Our Ref: TR030003

Date: 21 November 2017

Application by Port of Tilbury London Limited for an Order Granting Development Consent for a Proposed Port Terminal at the Former Tilbury Power Station ('Tilbury2')

Advice following issue of decision to accept the application for examination

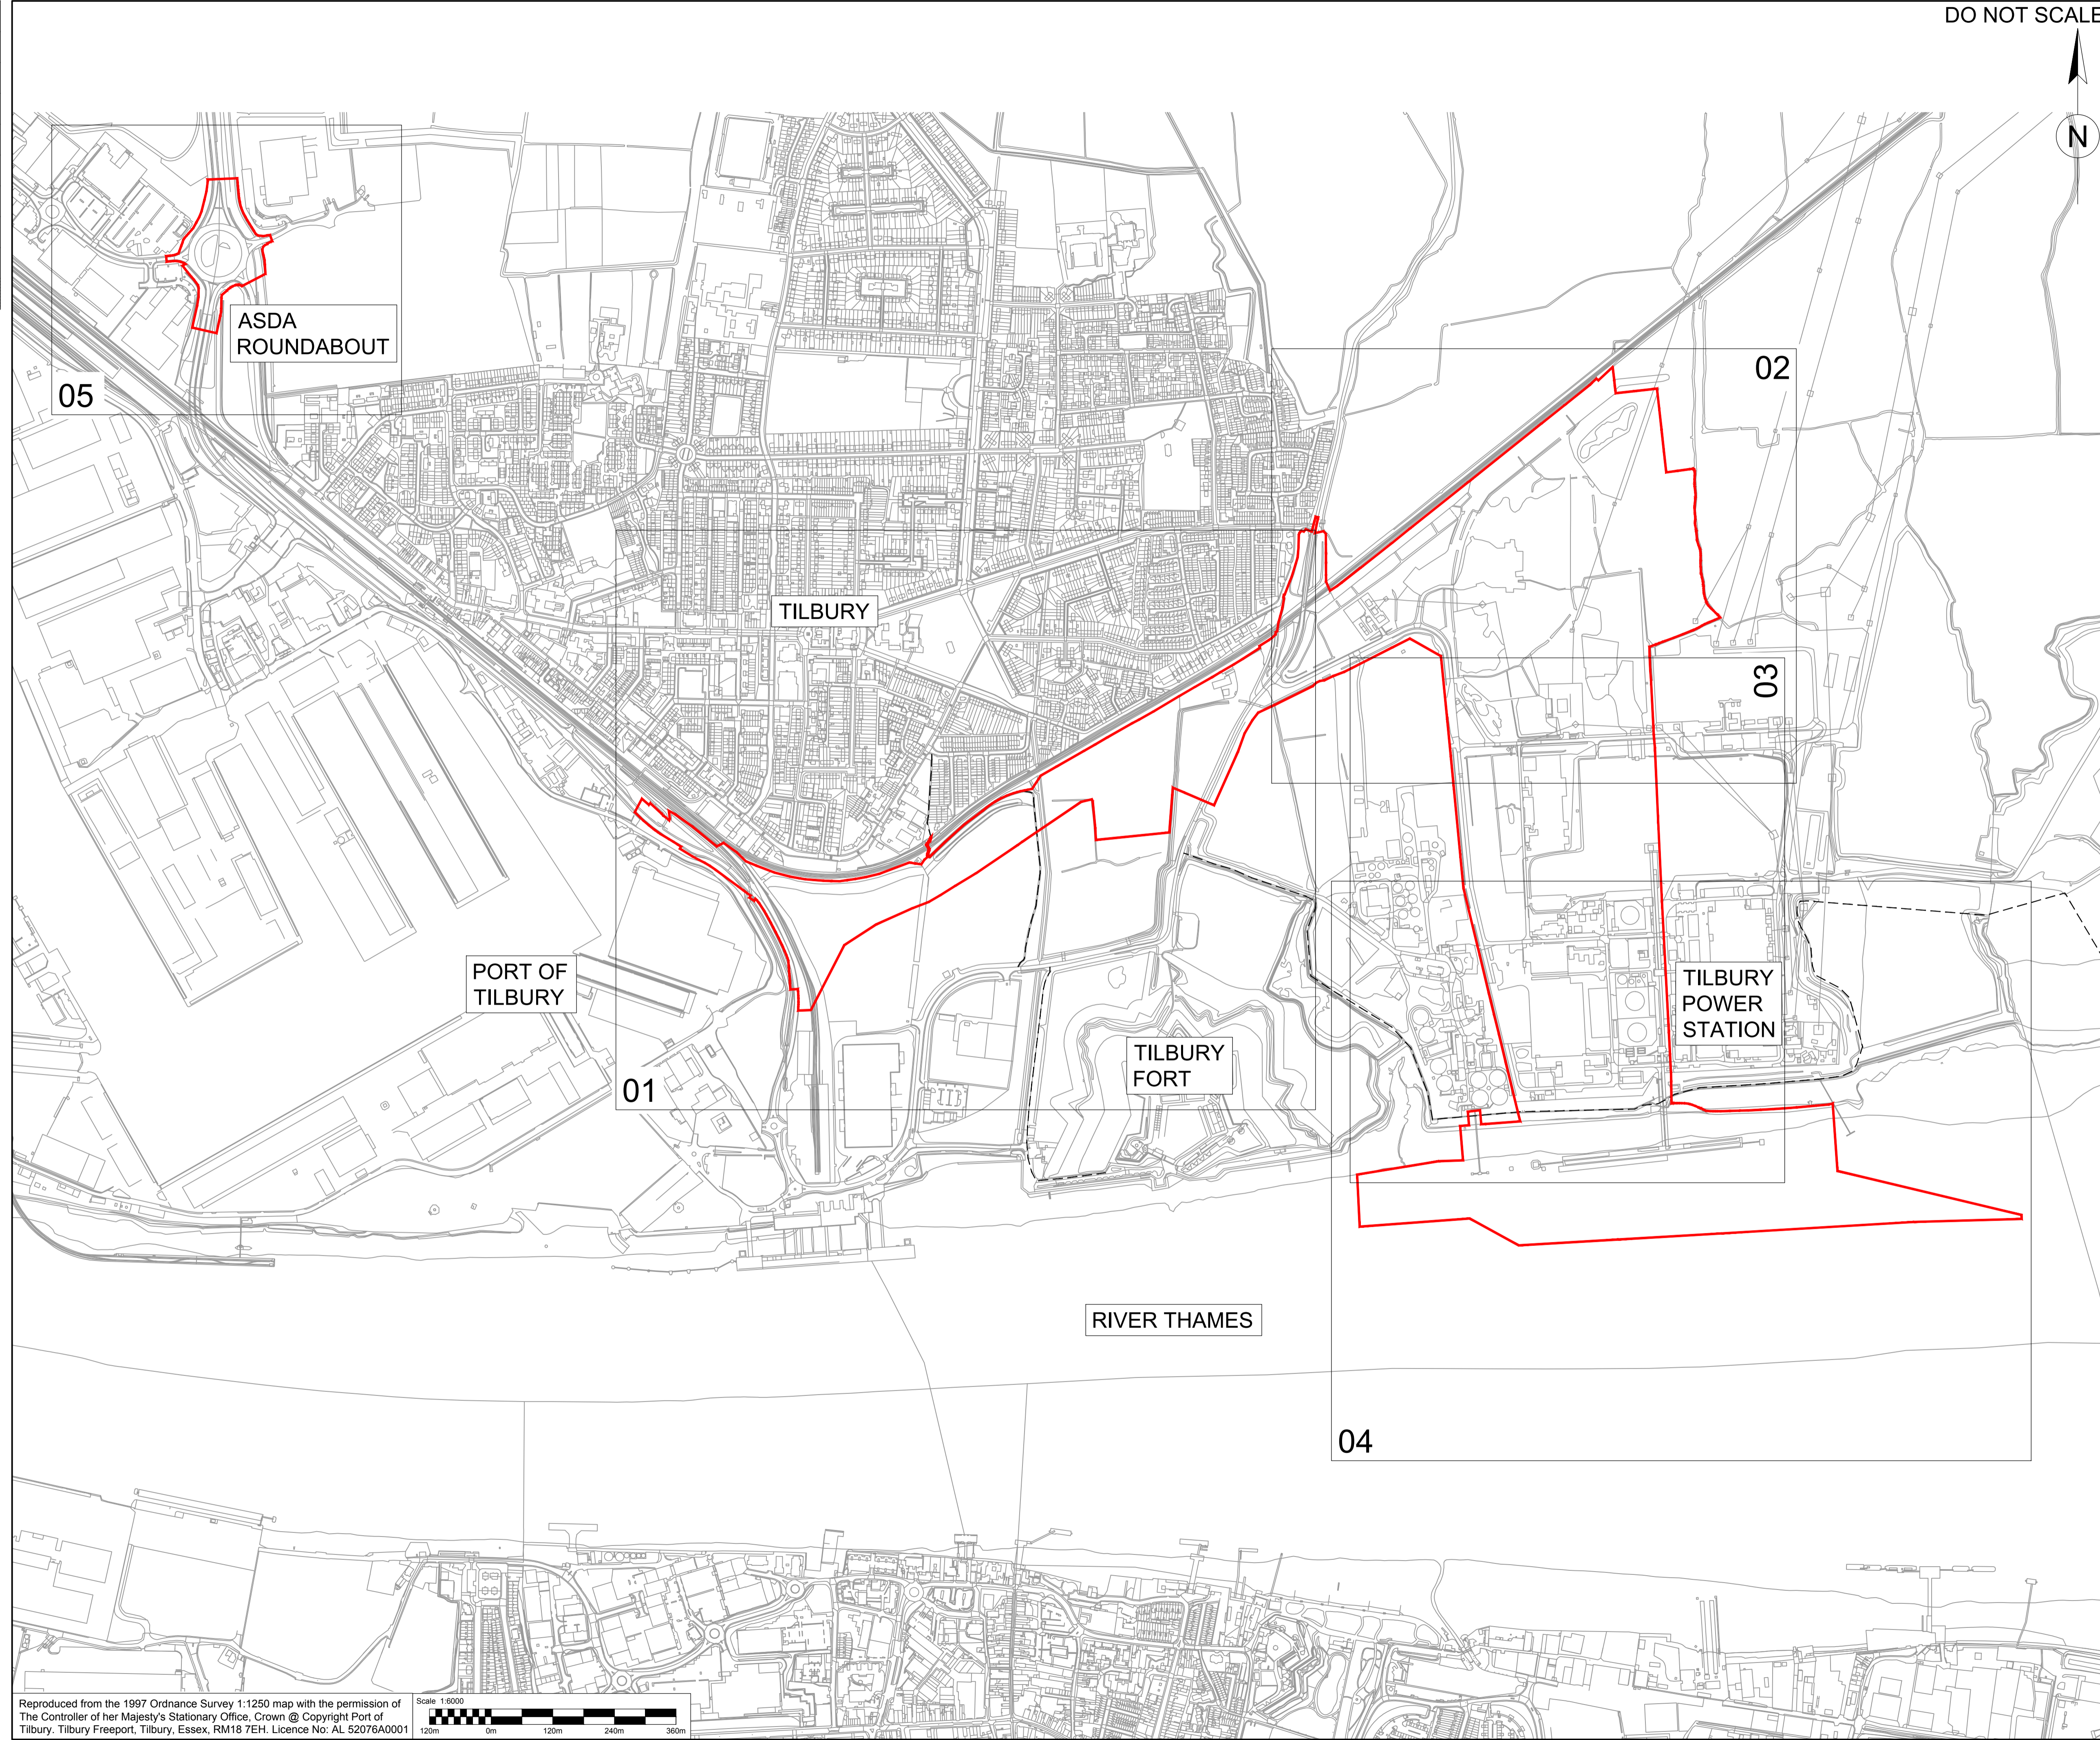
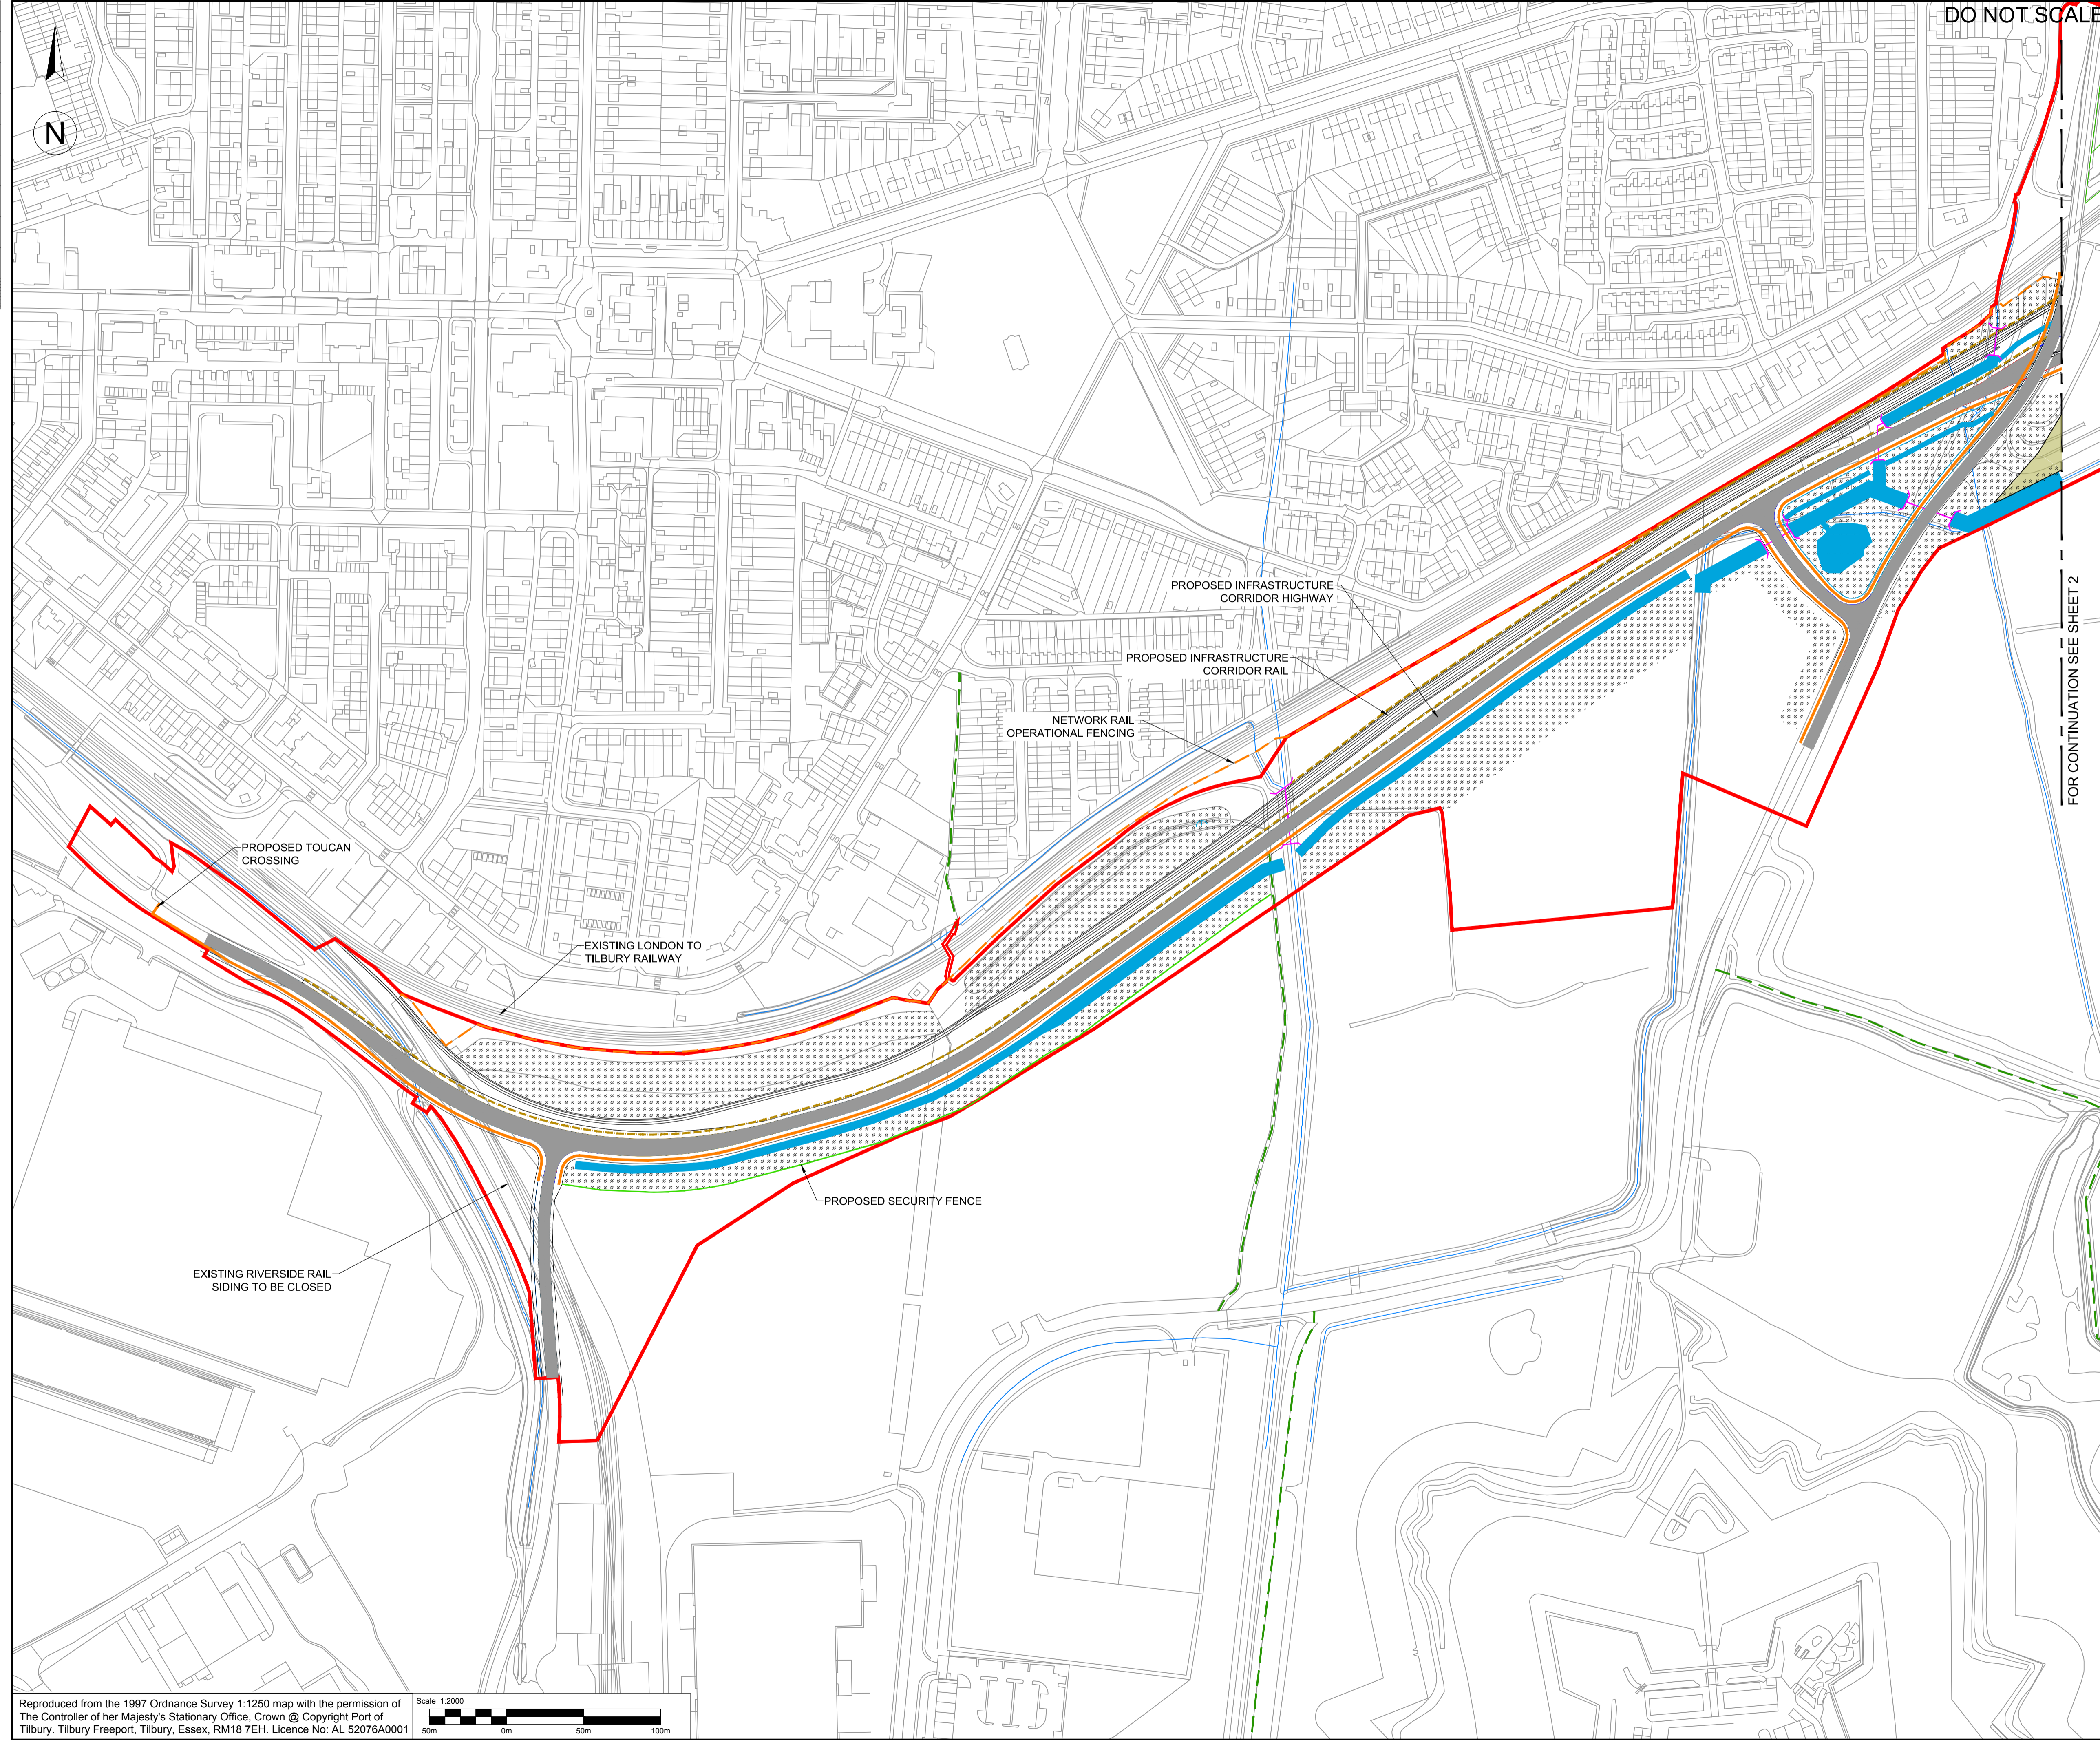
The Engineering Drawings and Plans (Doc 2.9) and the Works Plans (Doc 2.4) state "Do Not Scale". However, they are provided with scale details and a scale bar on each plan. In addition the General Arrangement Plans (Doc 2.2) and Engineering Drawings and Plans state, "Design shown is for illustrative purposes only", (or similar wording). We note that the Engineering Sections and Plans would become a certified document, should the DCO be made. In accordance with APFP Regulation 5(3), a scale is to be provided on these plans and drawings, and the Applicant should prepare for any questions the Examining Authority may have on this point.

Work No.1 includes the alteration and renewal of an existing flood defence. The existing flood wall is identified on the general arrangement plans; however, it is not clear from these plans precisely where the works would take place. Figure 6-3 of the Level 3 FRA (ES Appendix 16.B) contains a figure showing the existing floodwall; however, this figure is not clearly legible. The Applicant should prepare to be asked to revise and submit a new figure(s) to provide absolute clarity including the precise
